Article 21 of the Town and Country Planning (General Development Procedure) Order 1995
Application for approval of details reserved by conditions 3, 4 and 7 of LY/1/13 - Landscaping,
drainage & bat owl habitat
Barn at Calceto Lyminster,,

Arun District Council have decided to **REFUSE details reserved by condition for the following reasons:**

REVISION PROJECT Conversion of farm building at Calceto Farm, Lyminster		
SUBJECT Site Plan and Location Plan		
SCALE	DATE May 2013	DRAWING No 2012 / 23 / 13
DRAWN	CHECKED	
		Rev B

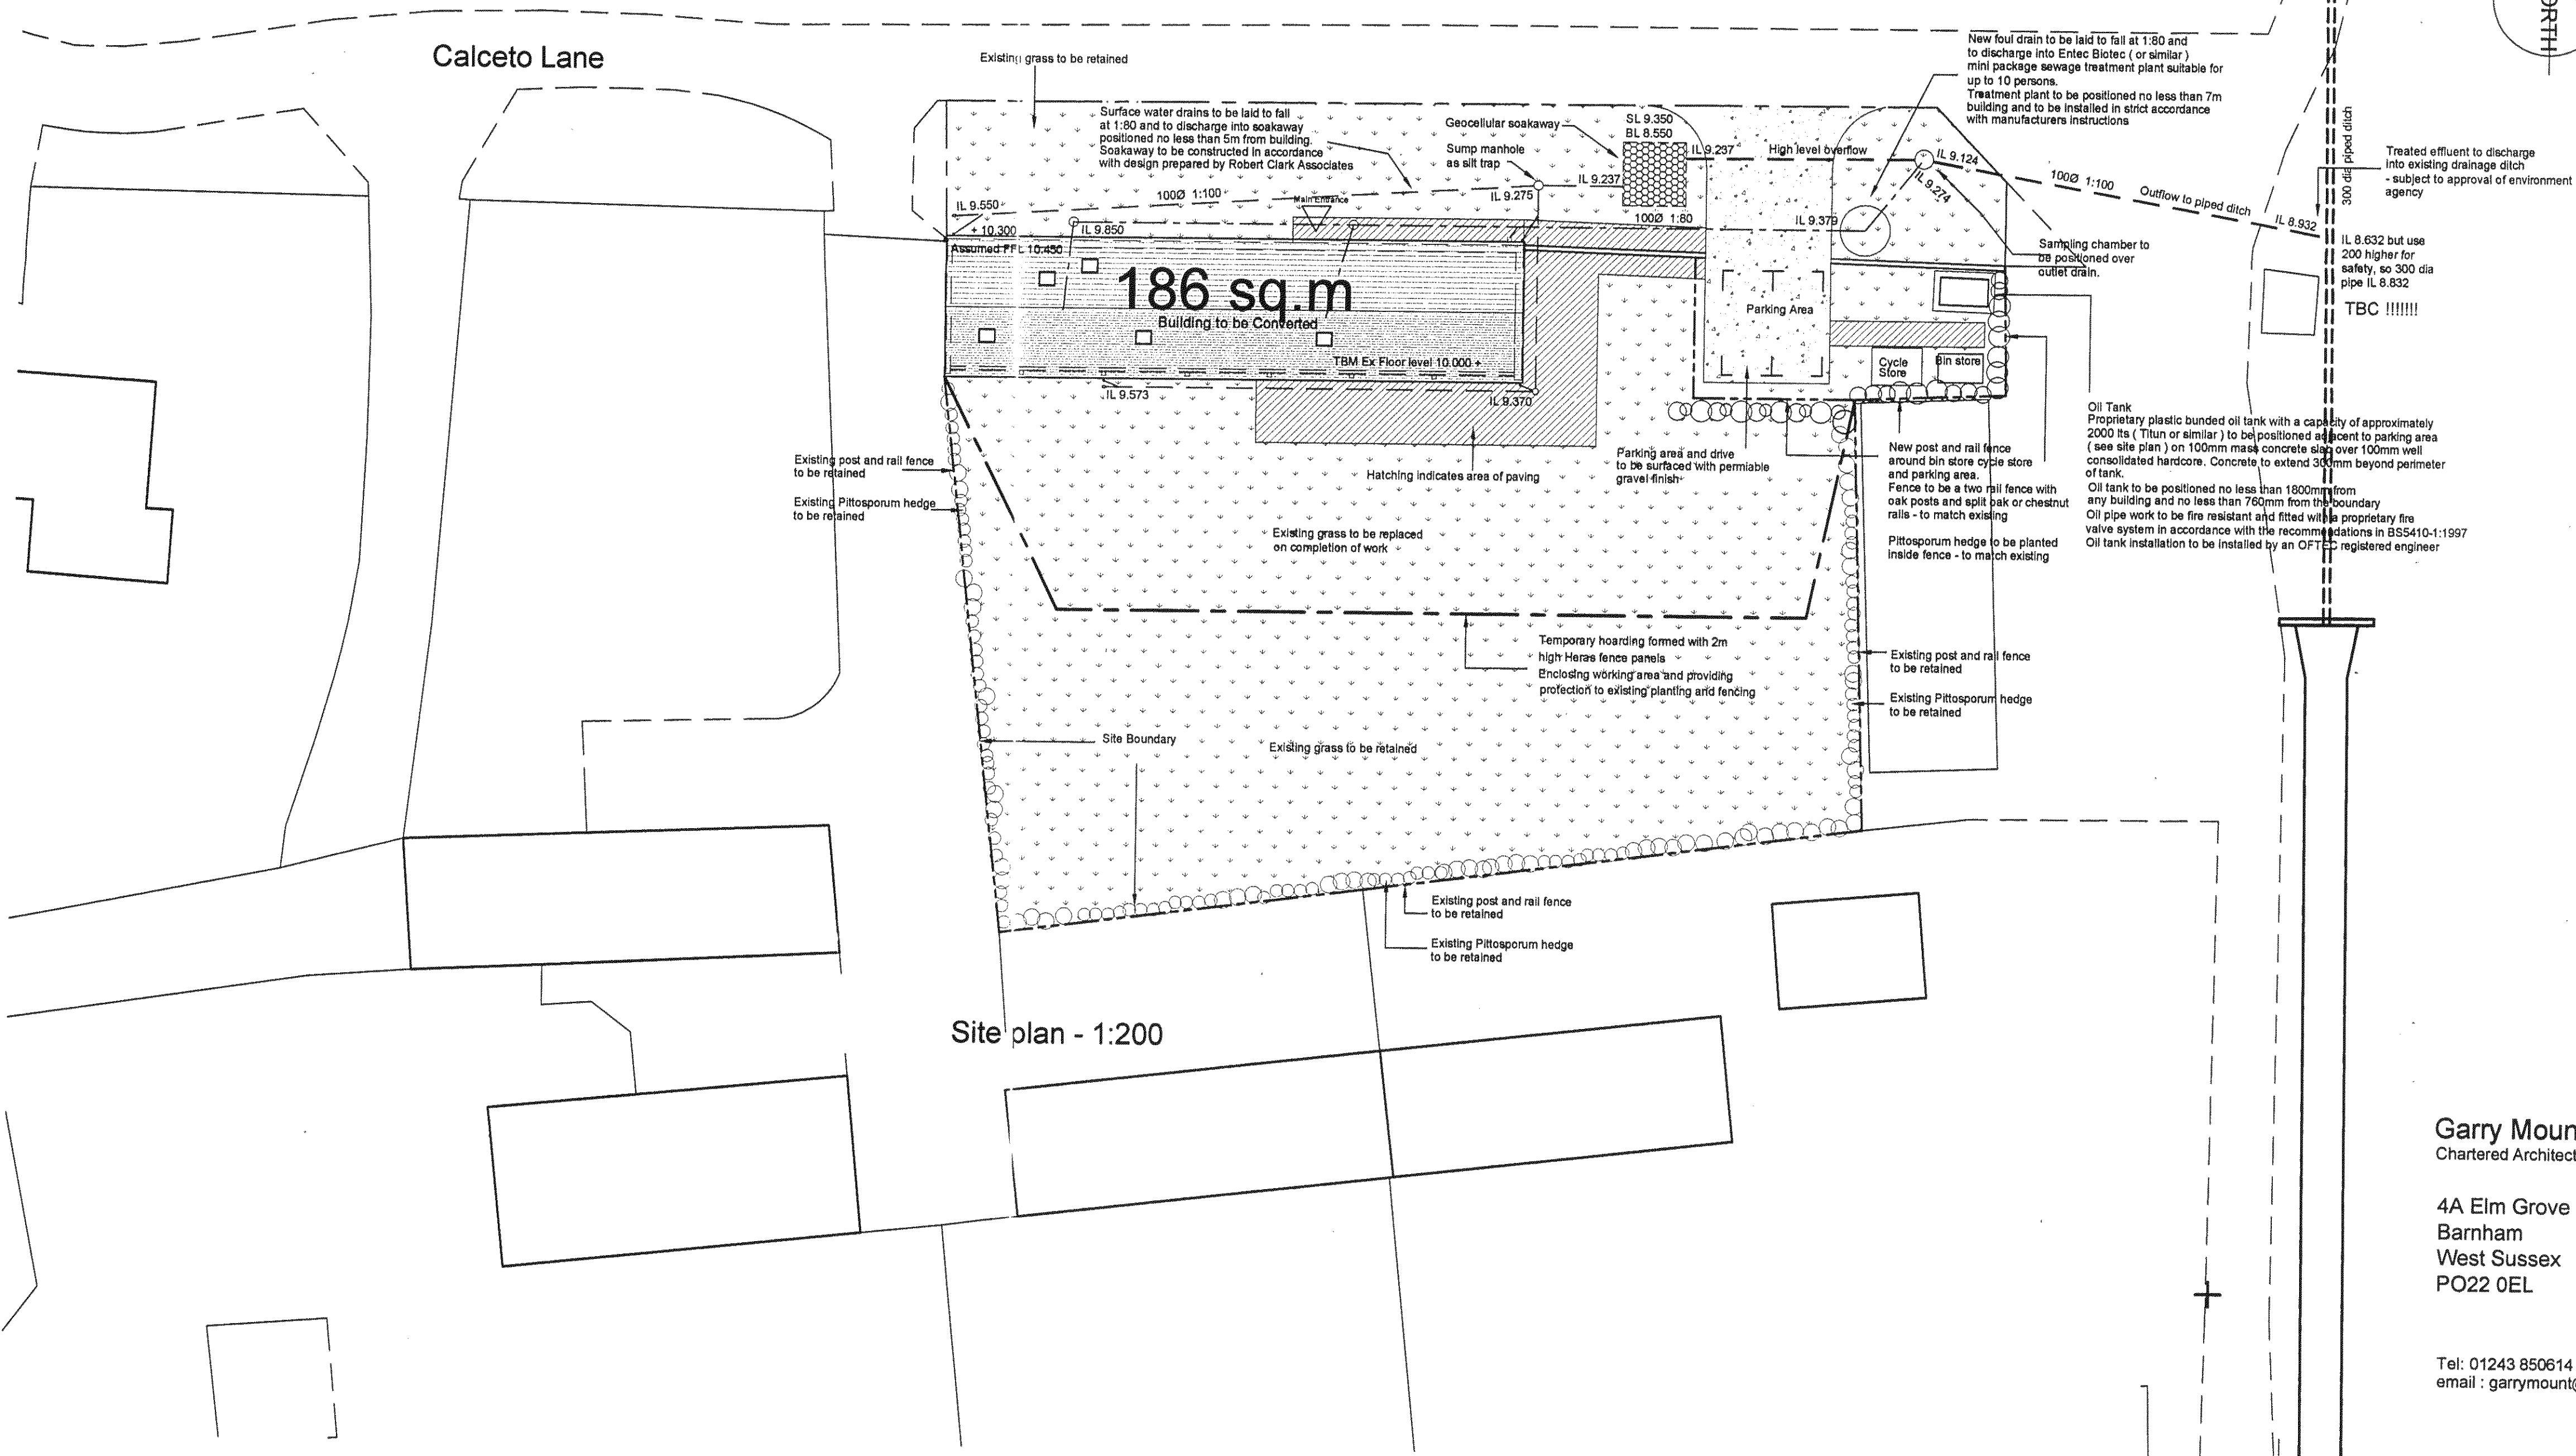
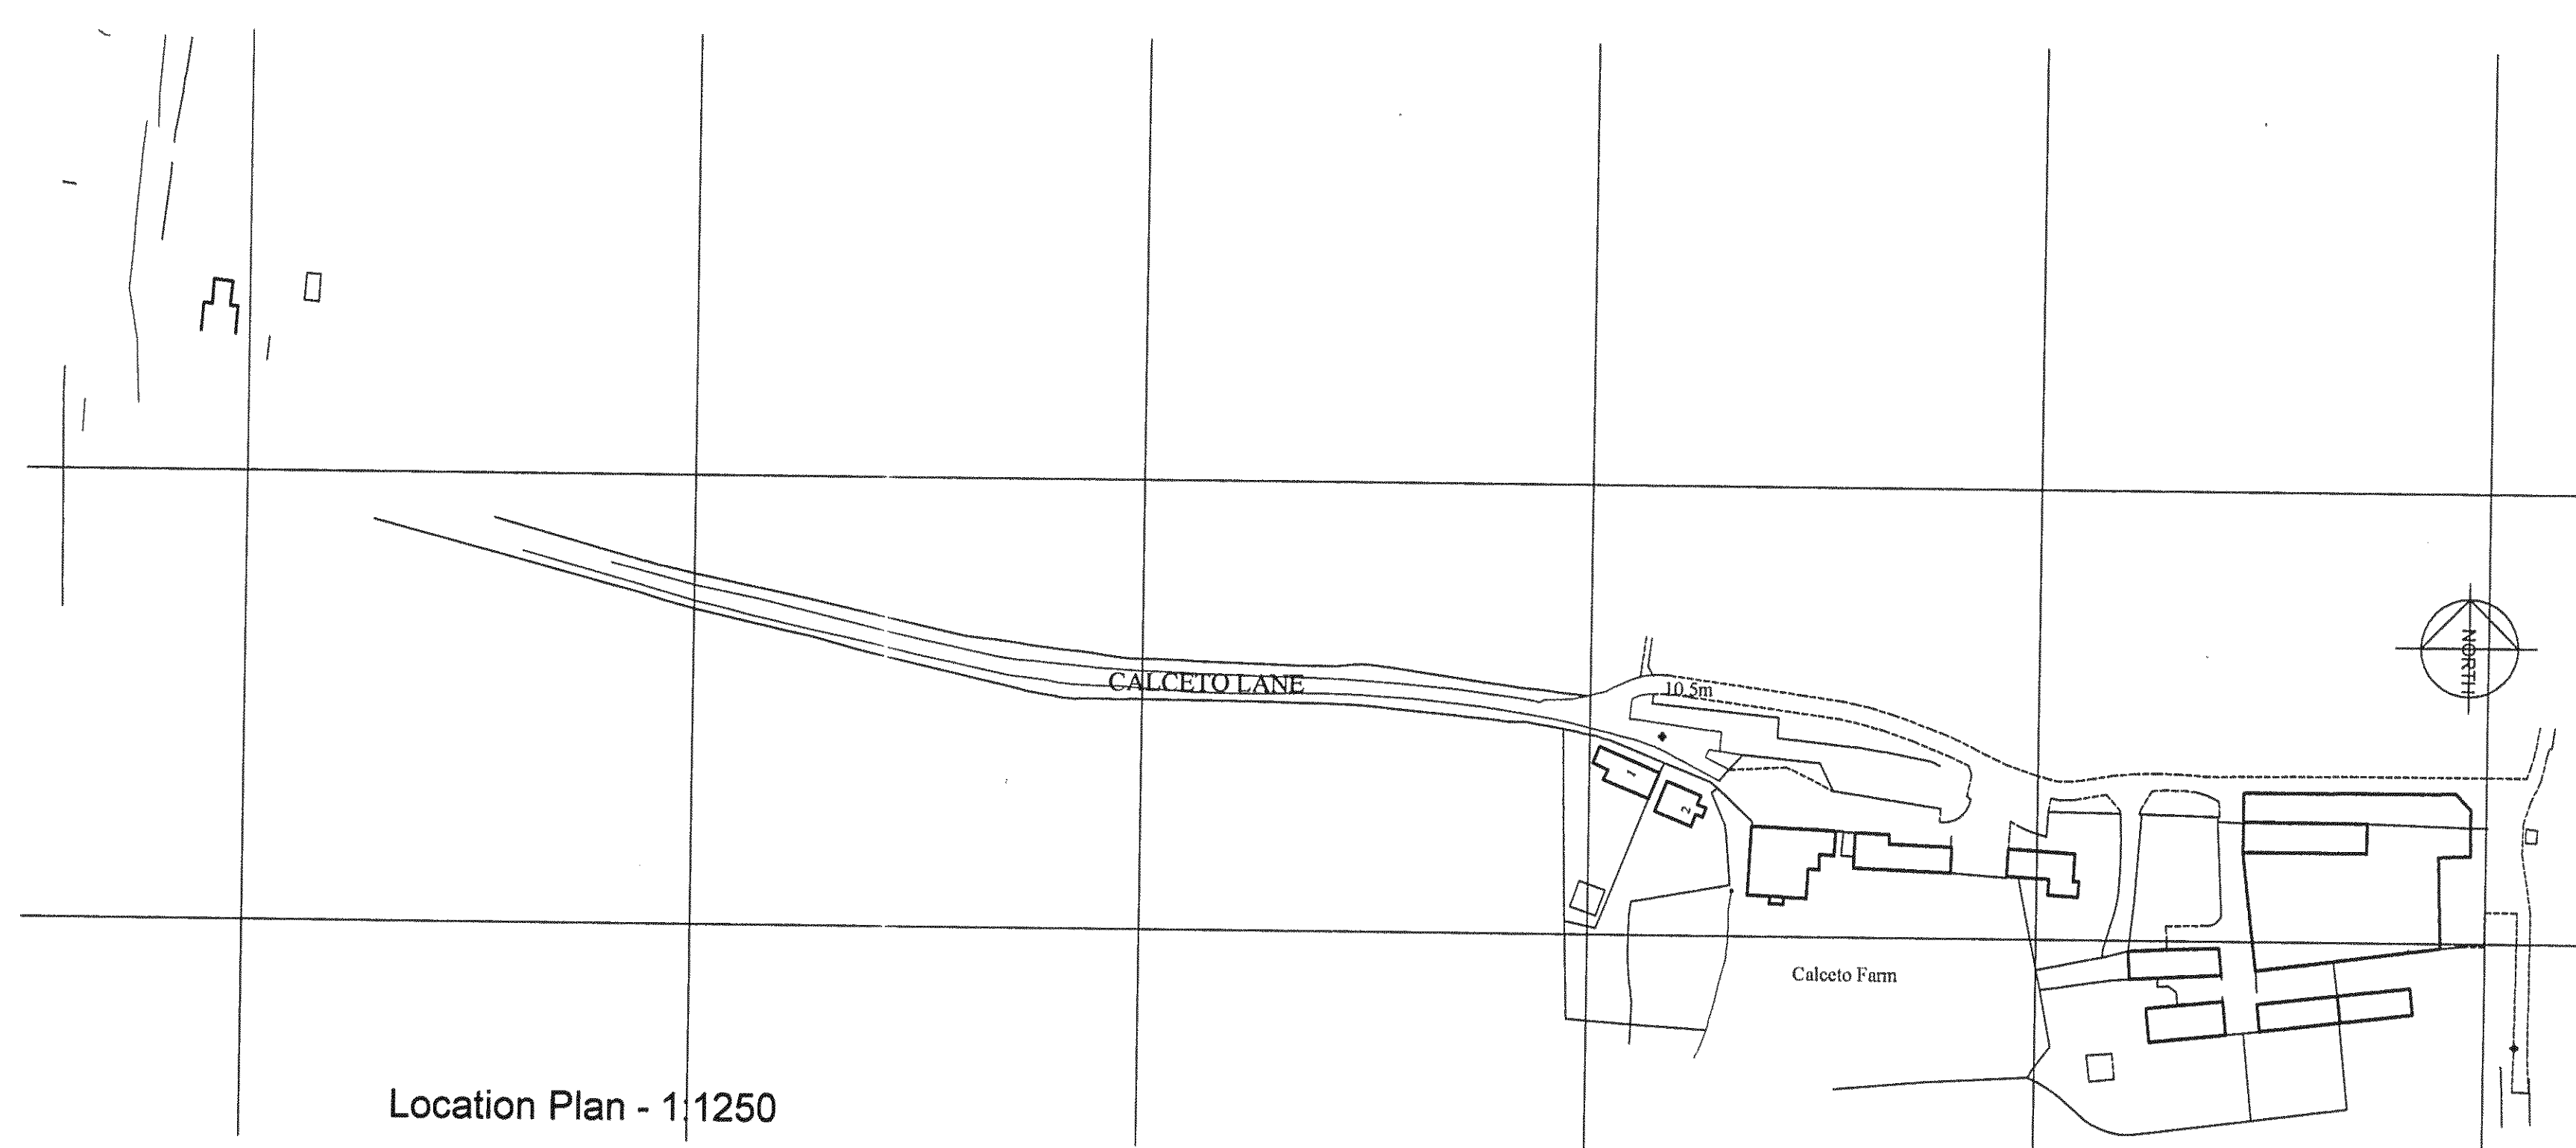
Whilst the details of the owl box are acceptable this condition cannot be discharged without precise details of the location of the tree at the southern end of the field where the owl box is proposed to be fixed.
